Ribble Valley Borough Council  
Housing & Development Control

Application no: **3/2019/0690**

Address: **Land adjacent to Elmridge Barn Elmridge Lane Chipping PR3 2NY**

Proposal: **Erection of a multi-functional barn for equestrian and agricultural use and equestrian arena with associated external lighting**

Proposed Site Layout

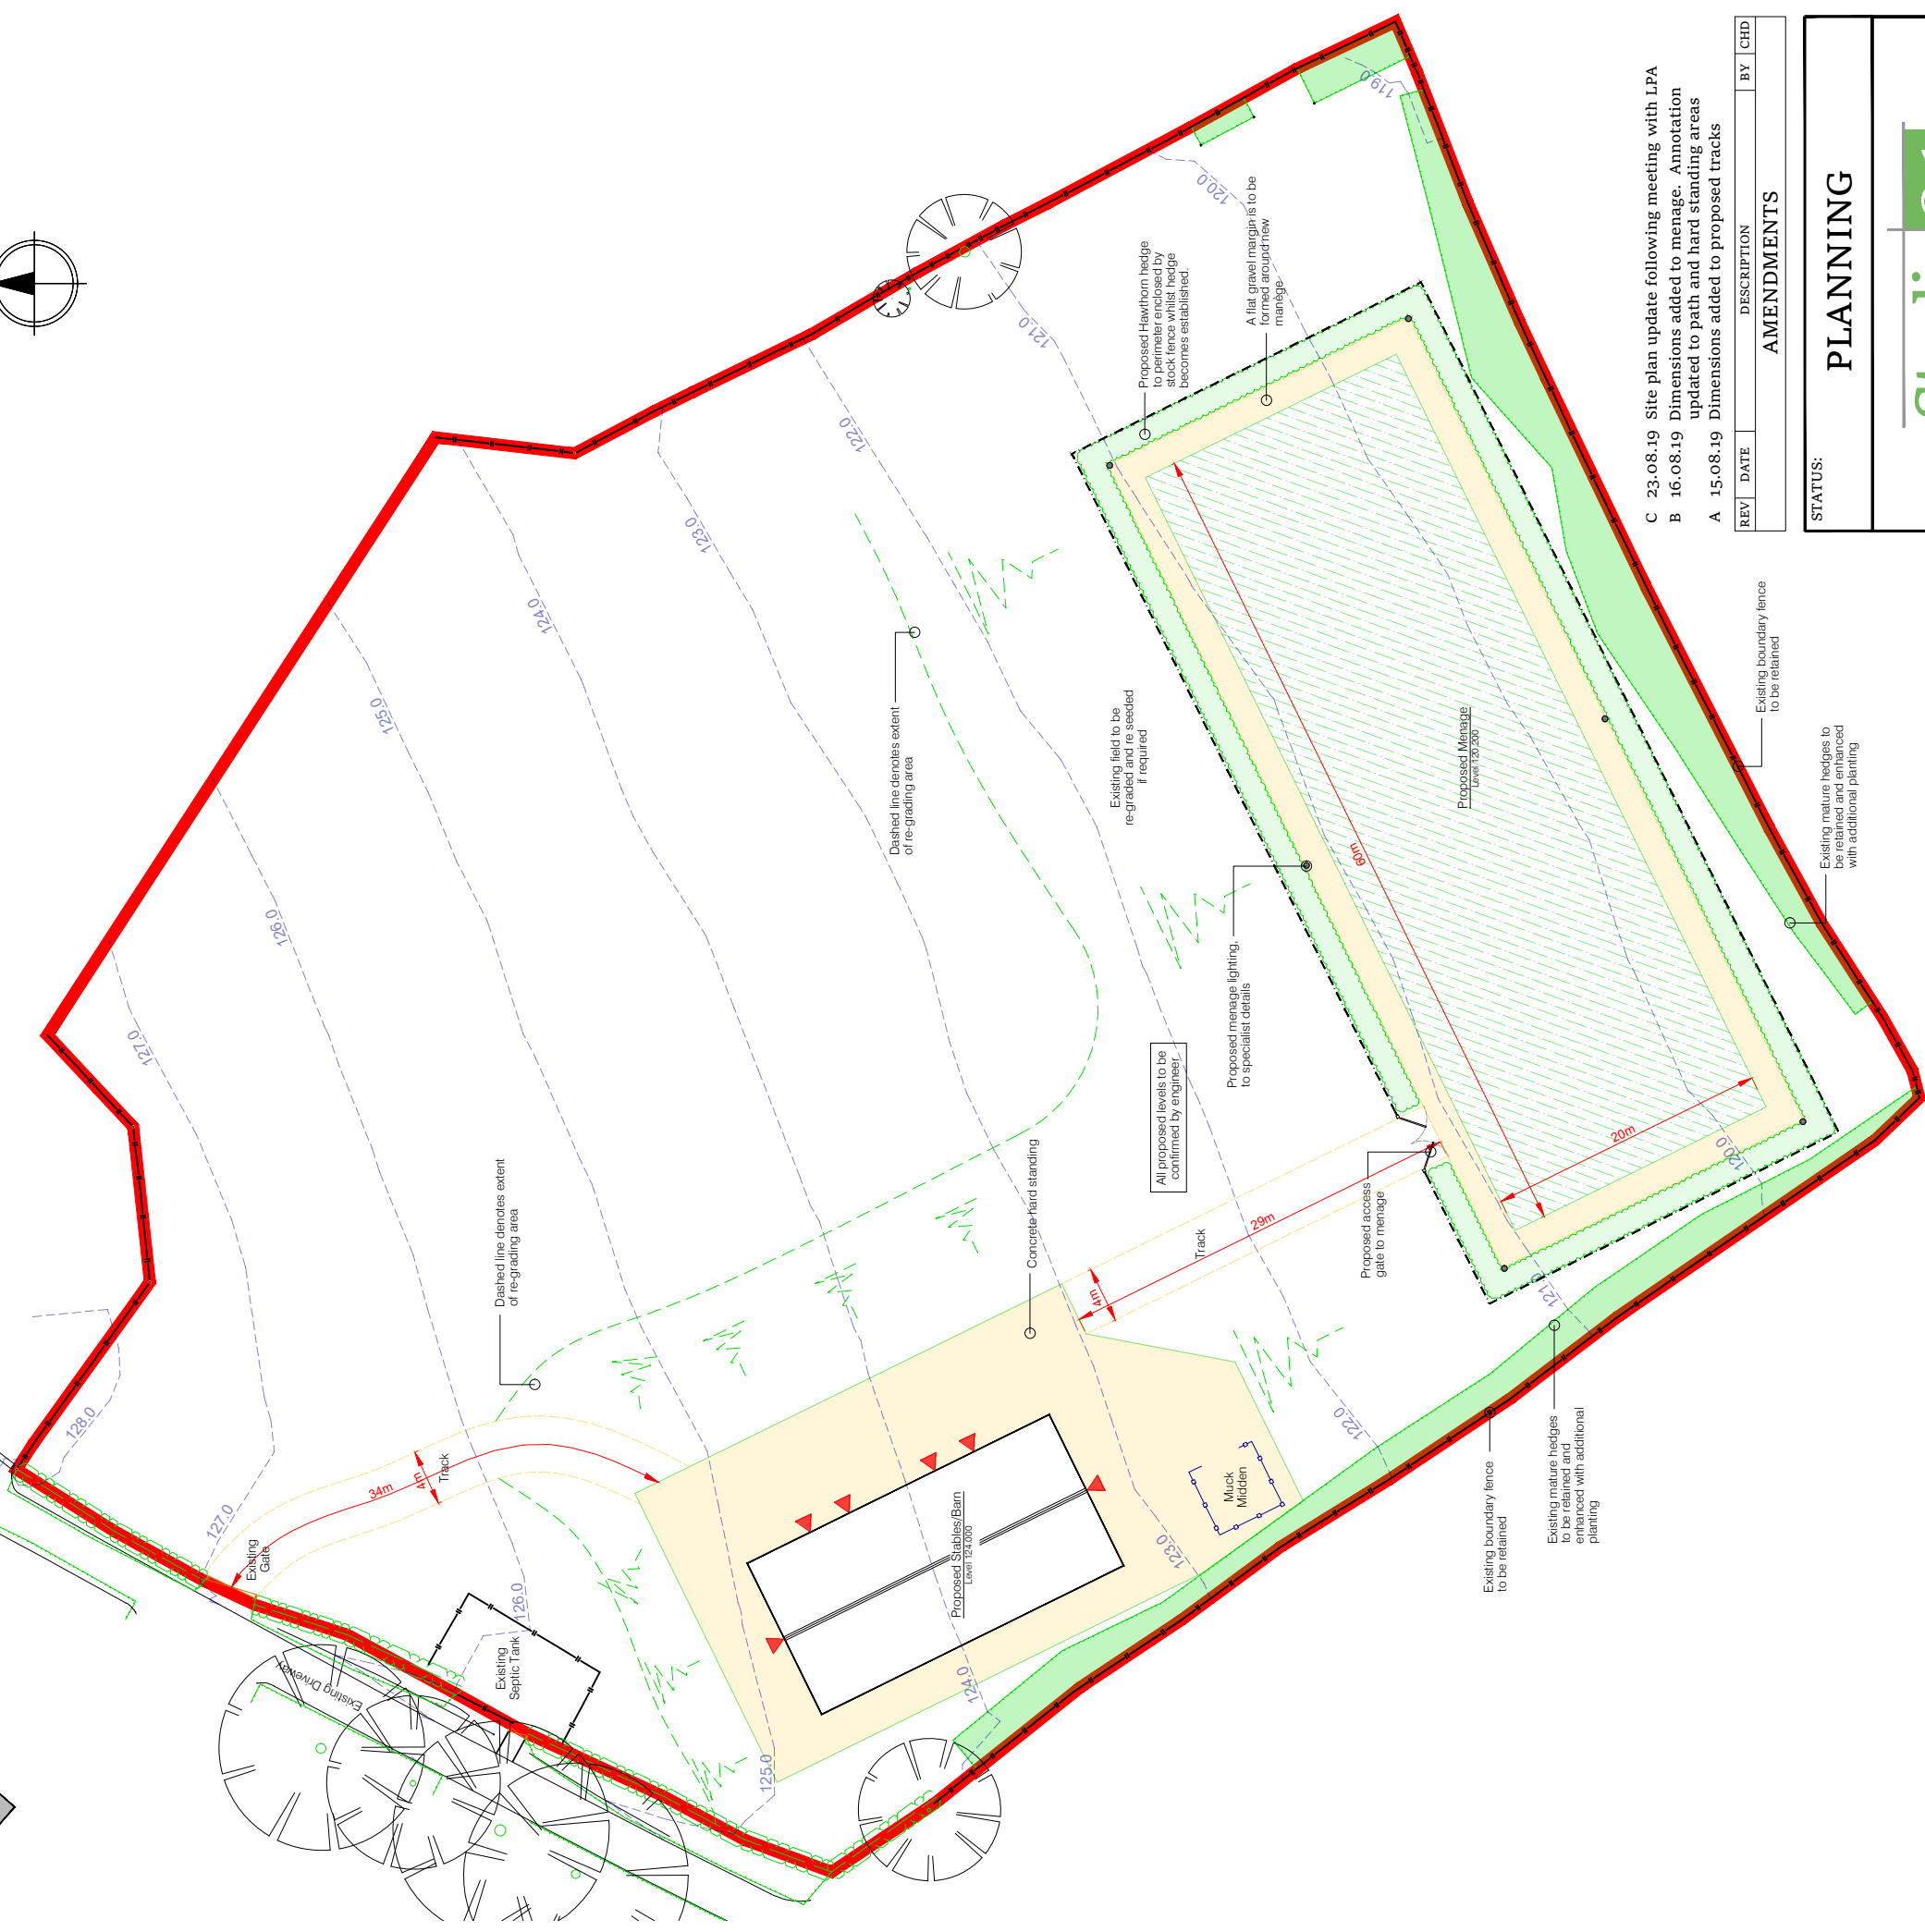
Access to the proposal is via an existing access point onto Elmridge Lane, an unclassified adopted highway, Road number U5204. Elmridge Lane is subject to the national speed limit and due to the nature of the road, and the works proposed to be carried out with regards to the earthworks, the applicant will be required to demonstrate a provision of wheel washing facilities and measures to control the emissions of dirt and dust during construction.

The proposal includes the construction of a 60m by 20m full dressage arena with associated external lighting. However, in accordance with the Planning and Design Statement, it is proposed that the ménage will be illuminated by six pole mounted LED lighting units, each of approximately 100 LUX. However when considering a ménage

would require an overall average light level of 100lux, an Iso-lux contour drawing would be required which would demonstrate how the proposed external lighting associated with the ménage would not be detrimental to highway safety.

1. Any external source of lighting shall be effectively screened from the view of a driver on the adjoining public highway. **Reason:** To avoid glare, dazzle or distraction to passing motorists.
